# Markup Summary

GRADING AND EROSION CONTROL PLAN

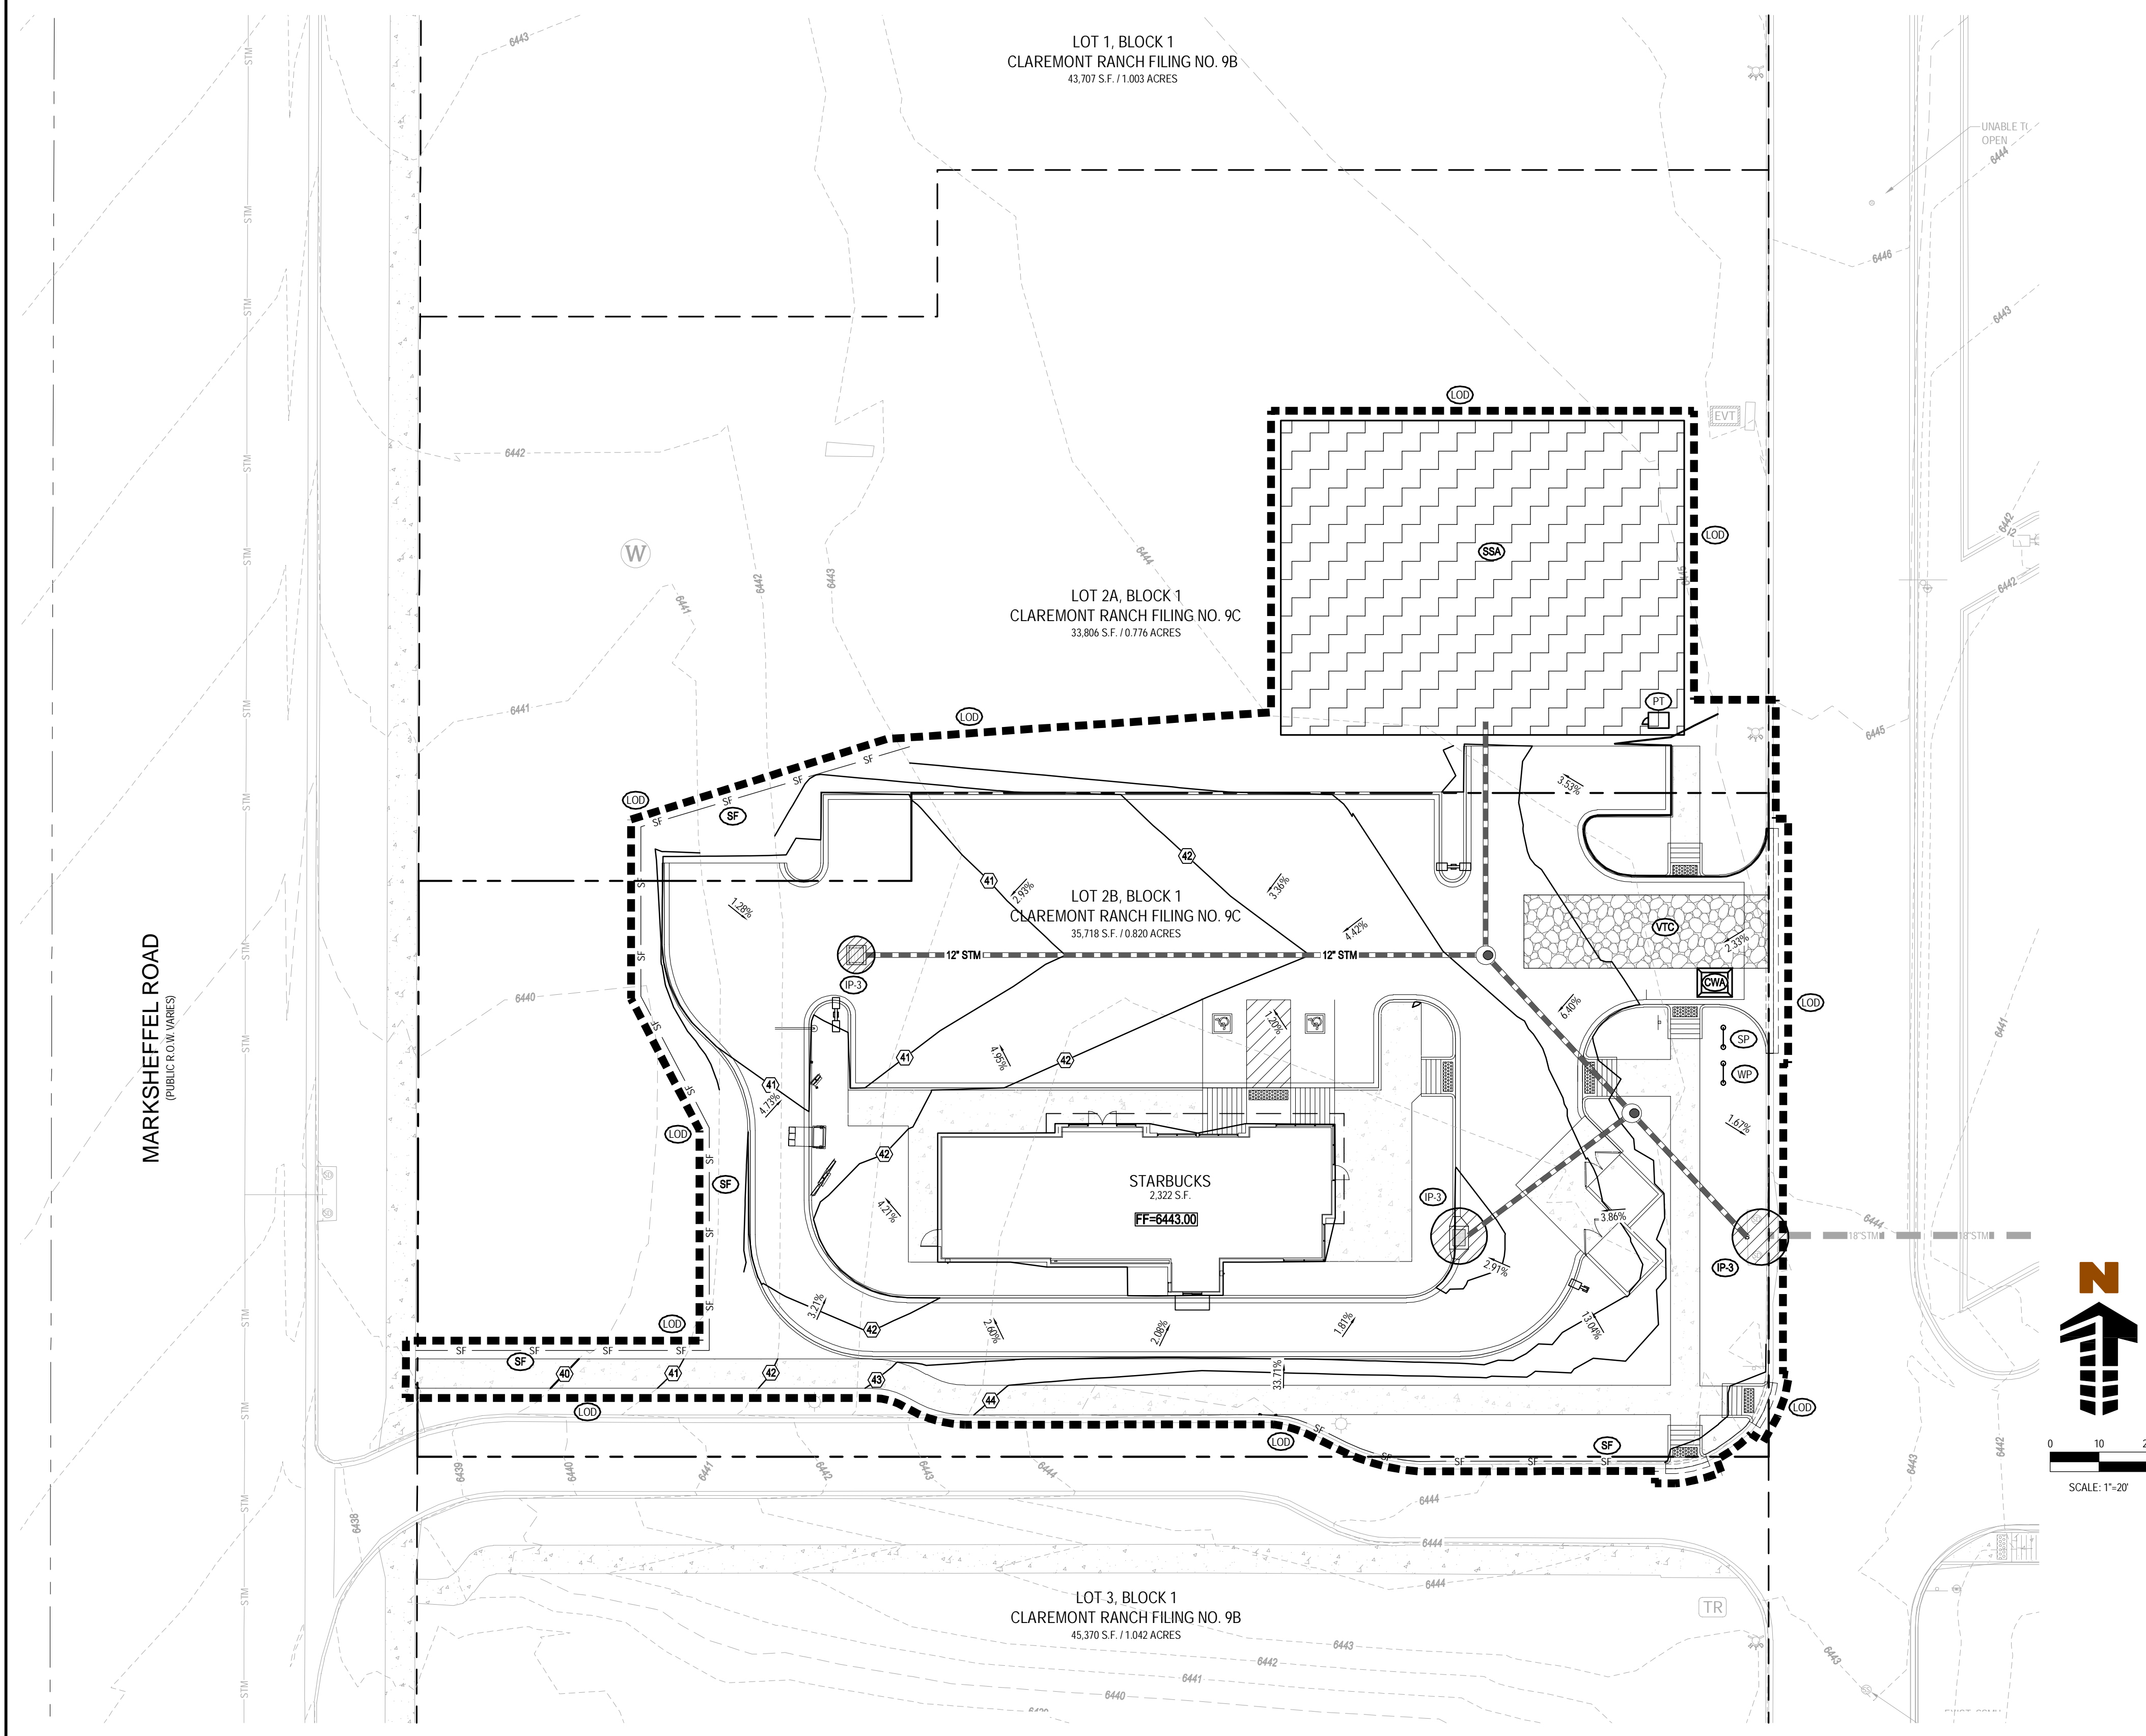
Remove the signature block from the site development plan set and include this in the standalone Grading and Erosion Control Cover Sheet.

Remove the Grading and Erosion Control sheet from the Site Development Plan Set.

The GEC Plan set is a stand alone document with it's own coversheet.

SITE PLAN

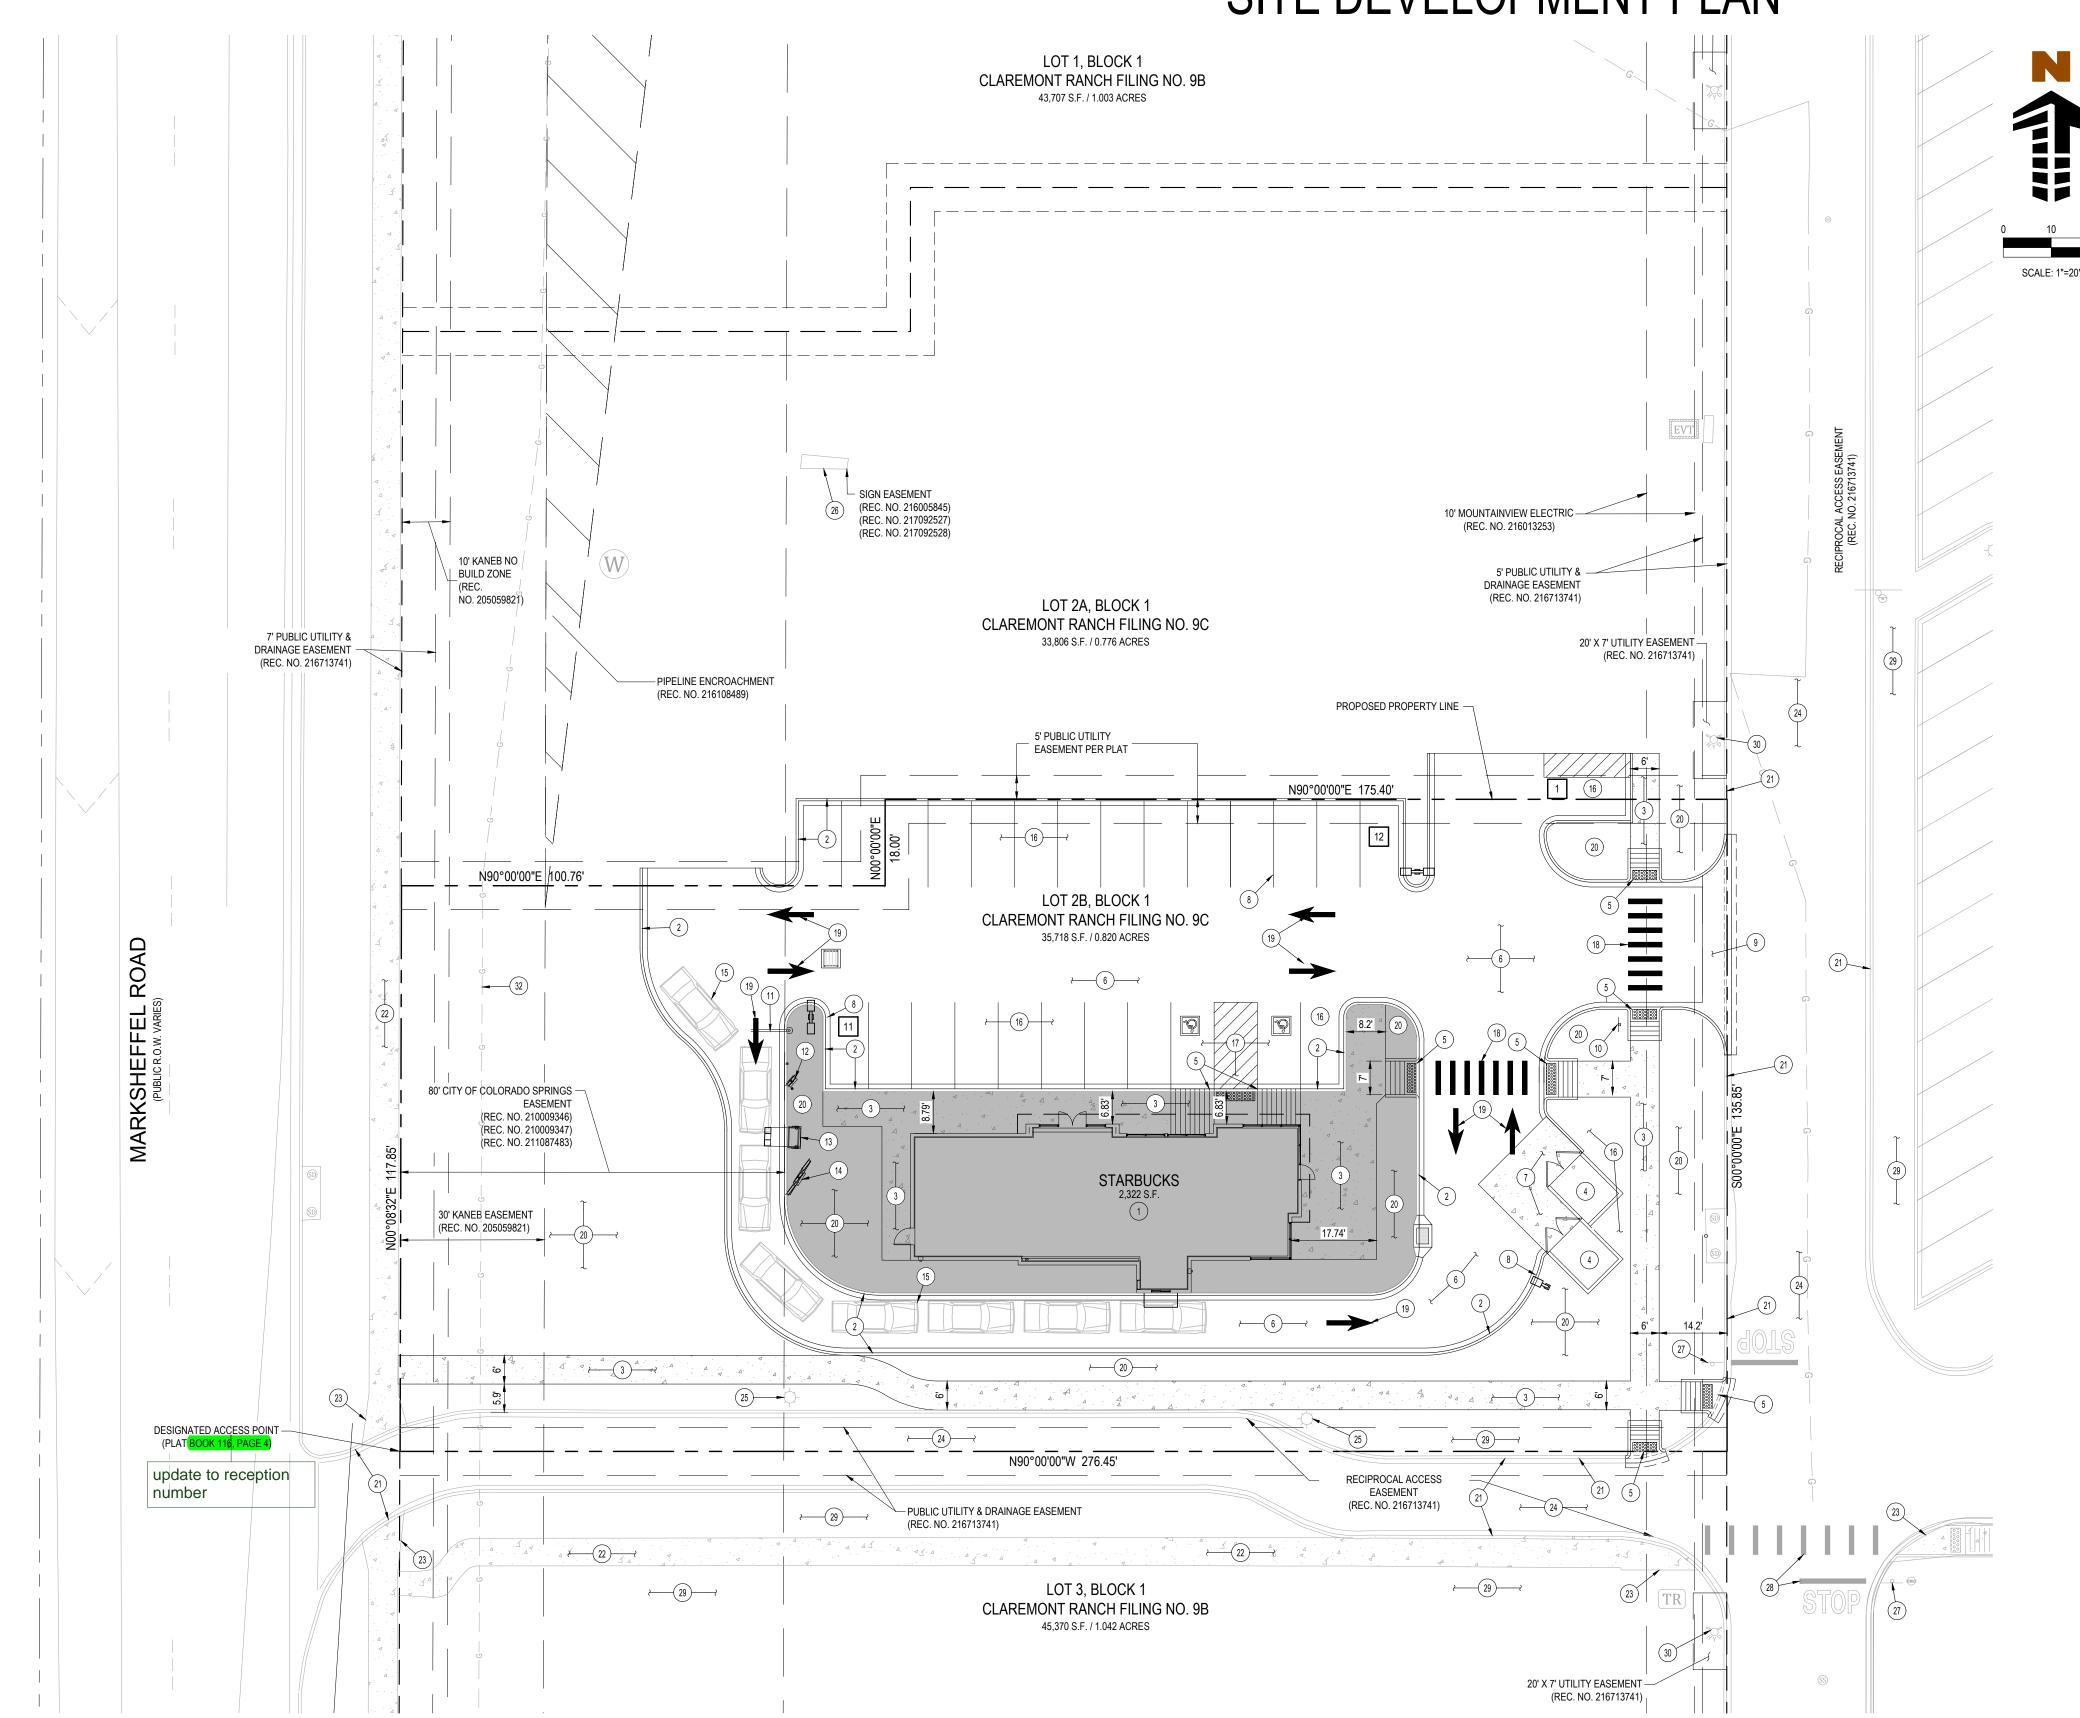
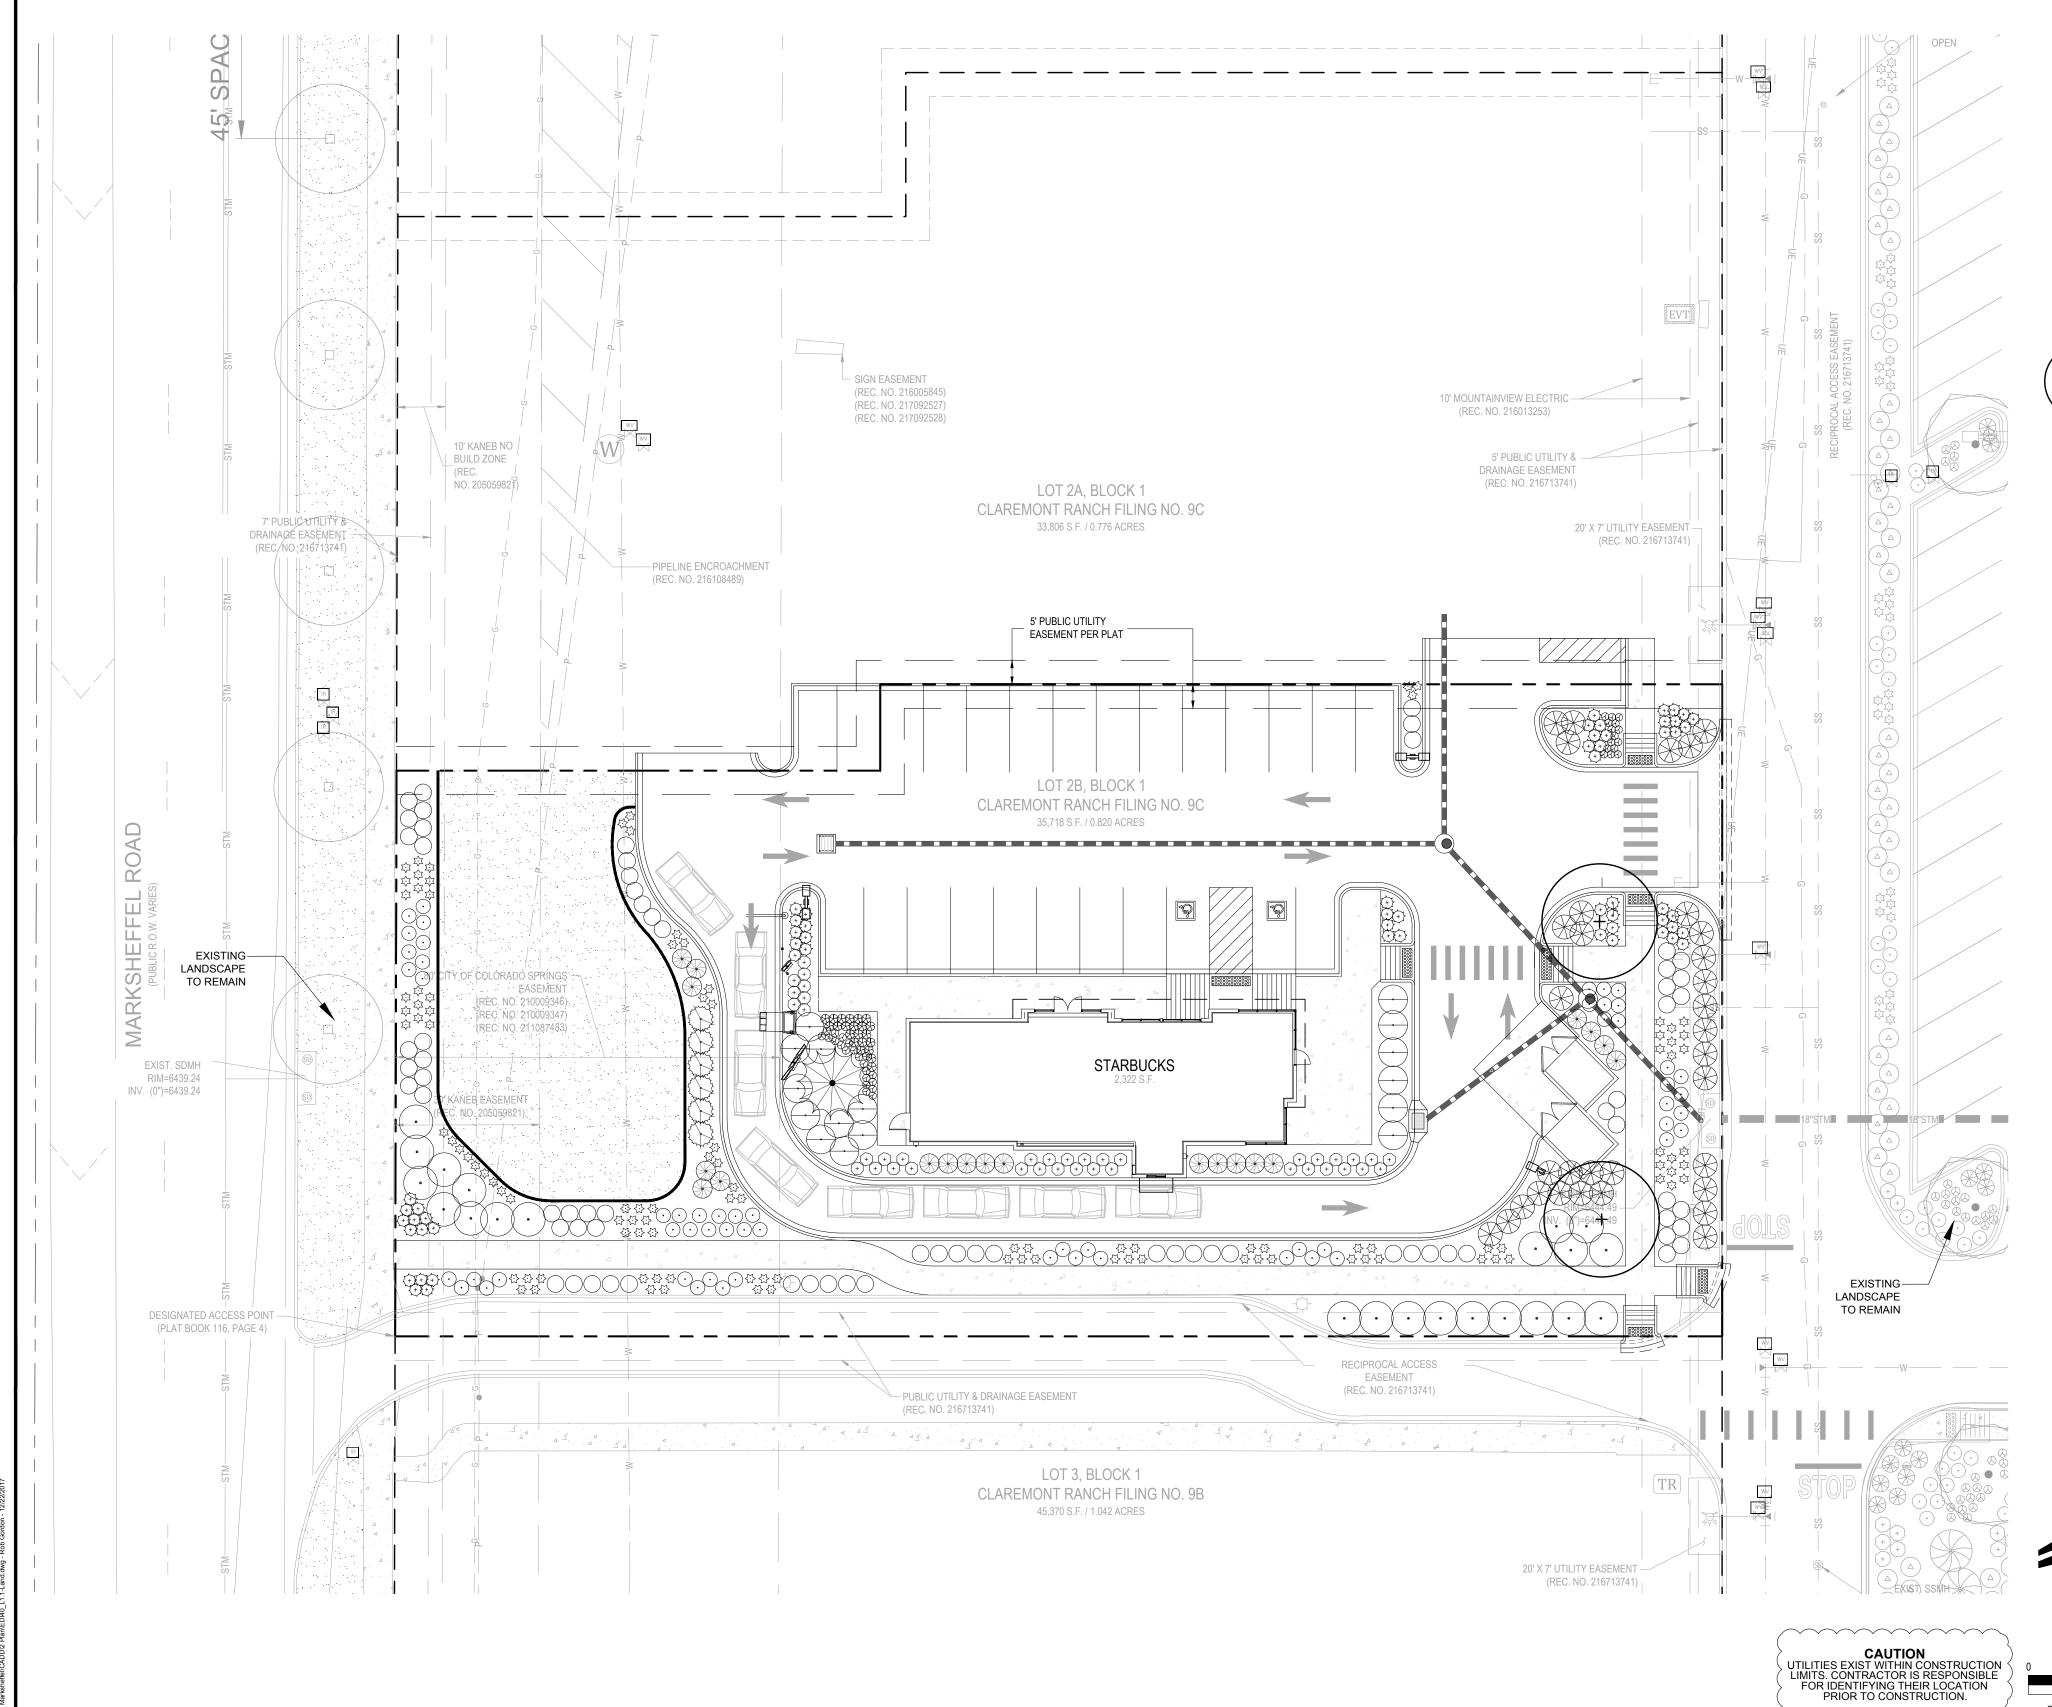
Add a dimension label from the sidewalk to the curb

Add a dimension label from the sidewalk to the curb or property line

If this is a shared access for future lot 2A then an access agreement needs to be recorded and noted on final plat

Update Reception numbers and Book and Page numbers per Vacate/Replat application notes
